DATE	January 4, 1980	JOB NO.	47-2-0003
ATTENTION	Mr. Subas Shaw, District Engineer		
RE:	Casita Vista Subdivision - Drainage		
RECEIVED			
JAN 6 1980

Re: Casita Vista Subdivision drainage plan

Reference: Casita Vista Development

CASITA VISTA

CITY OF ALBUQUERQUE PUBLIC WORKS DEPARTMENT ENGINEERING DIVISION					
TITLE: CASITA VISTA REAR YARD DRAIN LINE					
APPROVALS	ENGINEER	DATE	APPROVALS	ENGINEER	DATE
City Engineer			Liquid Waste		
ACE Design			Traffic		
ACE Hydrology			Water		
DRAWING NO.			SHEET 5 OF 5

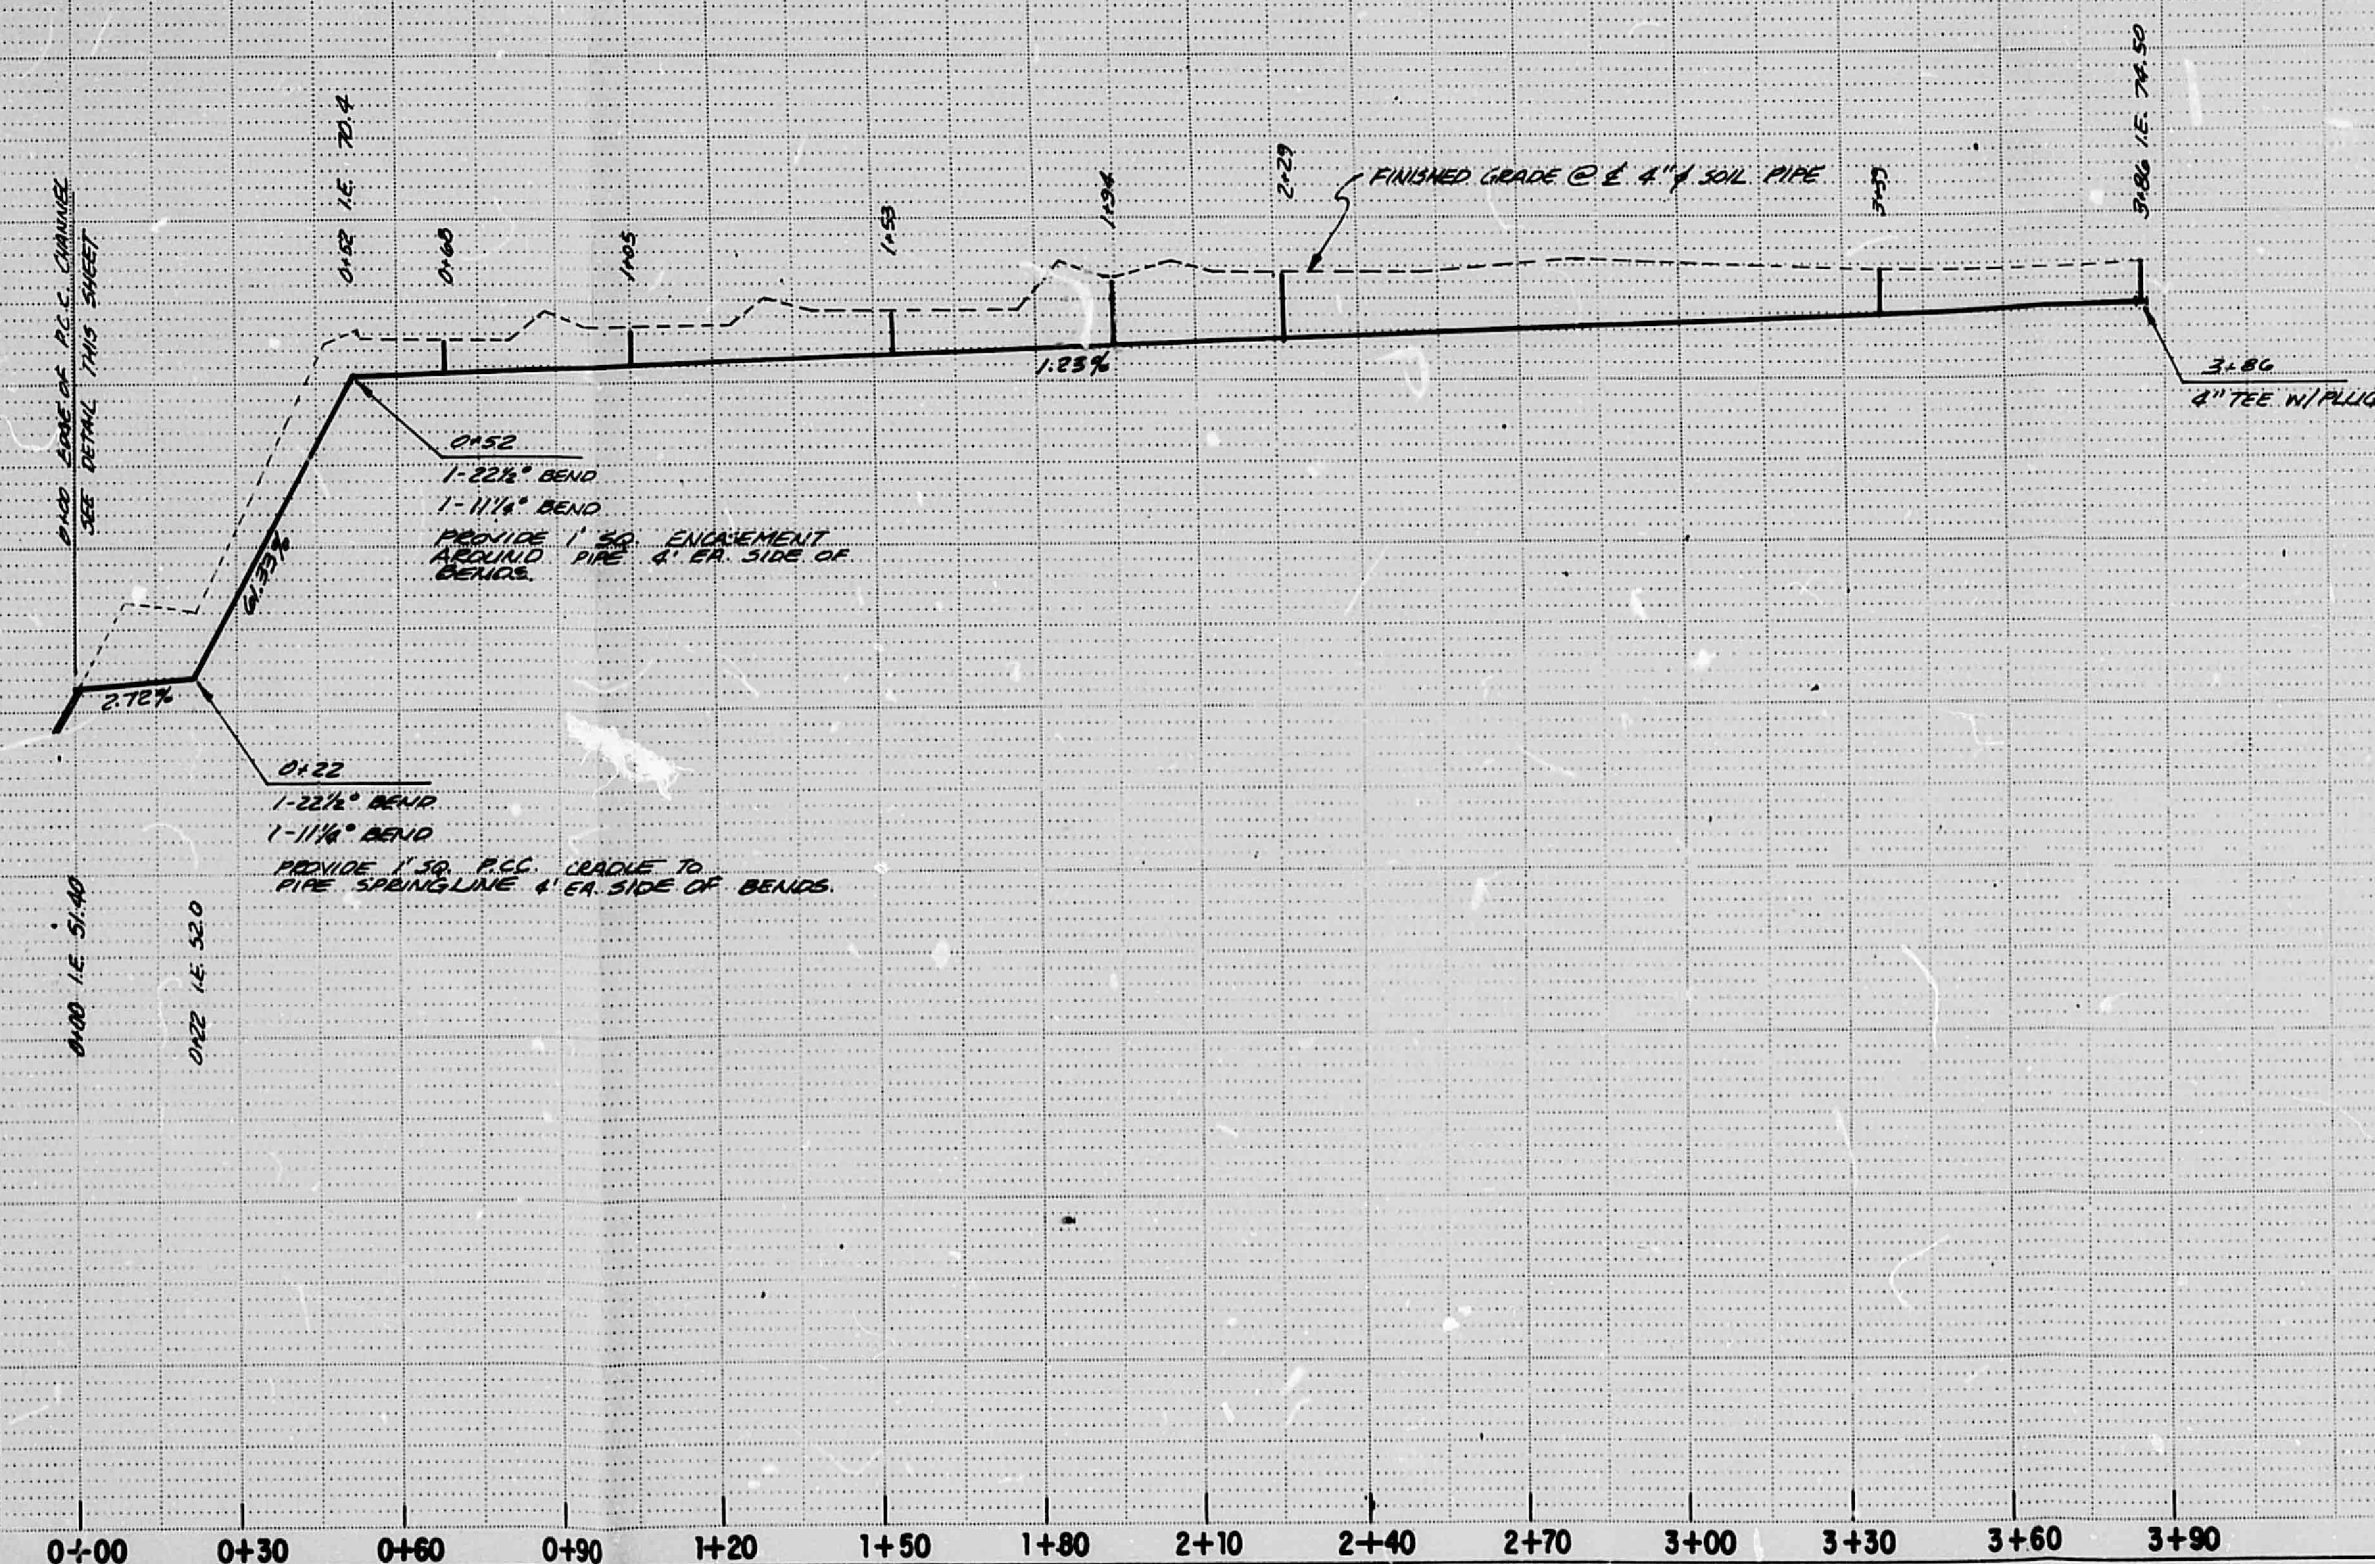
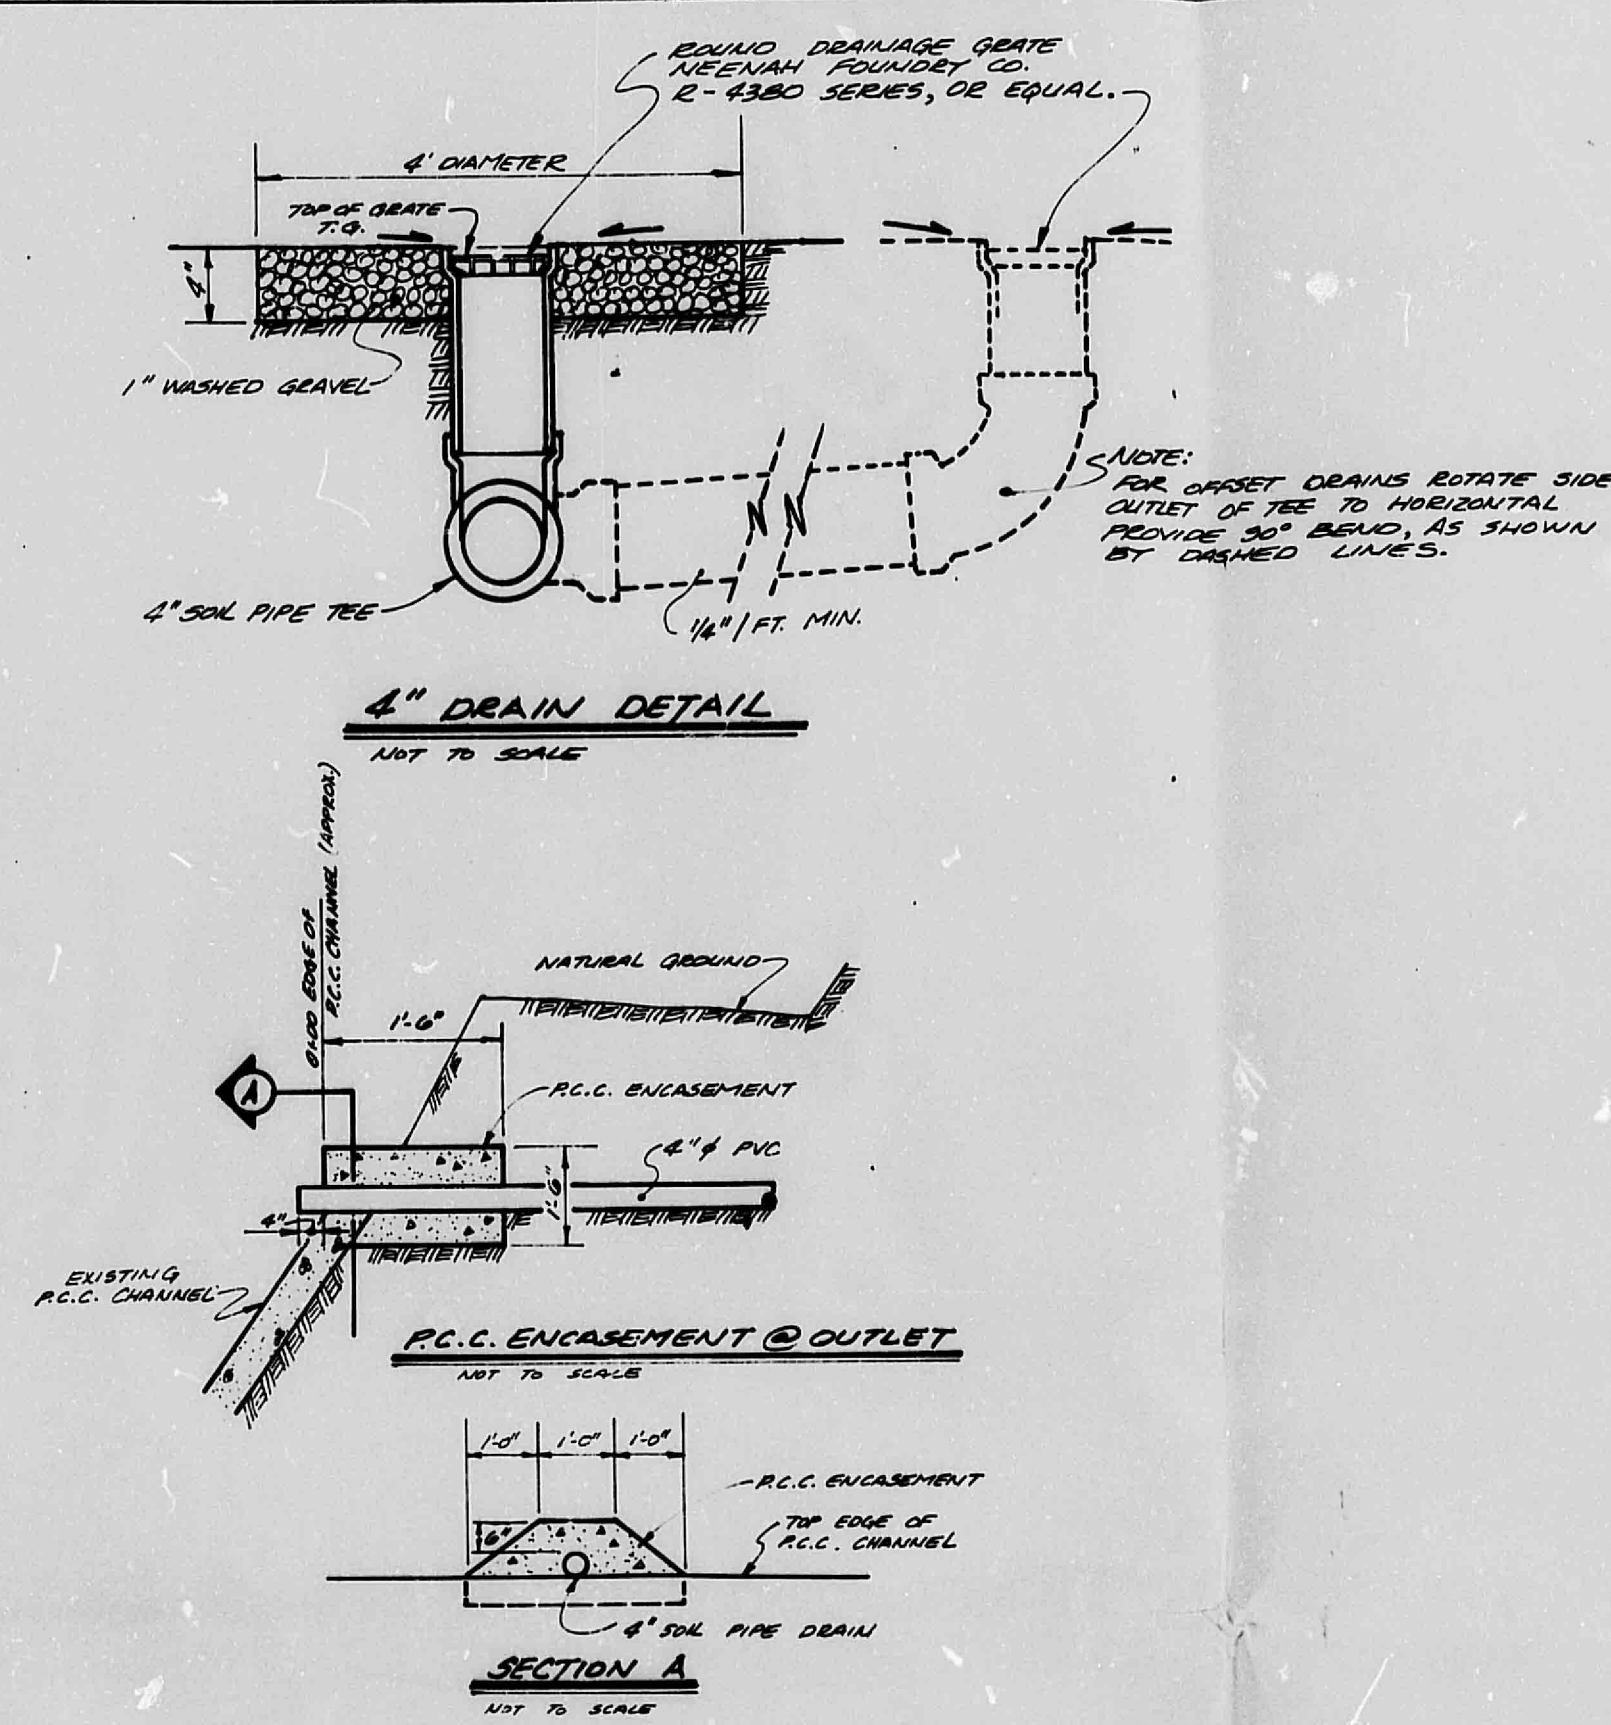
As we discussed, the District policy calls for no acceptance of any surface runoff into the District facilities, provided it threatens the damage to the District property and facilities. The Arenal Main Canal in the vicinity of your project is concrete lined and uncontrolled runoff would cause damage to the concrete lining.

- 1) The outlet drain pipes should be connected into one main drain pipe.
- 2) Only one drain inlet will be permitted from your property to drain into Arenal Main Canal.
- 3) The 4" drain pipe should drain directly into the canal. No sheet flow into District banks will be permitted.
- 4) Adequate cover should be provided over the drain pipe to avoid any damage due to District vehicles.
- 5) The developer or the City will be responsible for proper maintenance of the drainage system.
- 6) It is expected that the runoff received into the system will be free from contamination, grease, silt, etc.
- 7) A license is required from the District for a drain inlet. Please furnish final plans with these modifications.

To accomplish this objective we propose to furnish each pond with a small outlet drain which would empty the pond at a controlled rate. The discharge from these drains would be collected into two 4" diameter PVC pipes (one draining to the NE corner of the parcel and one to the SE corner). Flows would be released at the toe of the embankment onto a small rip rap pad and would sheet from the pad into the Arenal Drain. Peak discharge from the two pipes combined would be limited to 1 cfs for the "pond full" condition.
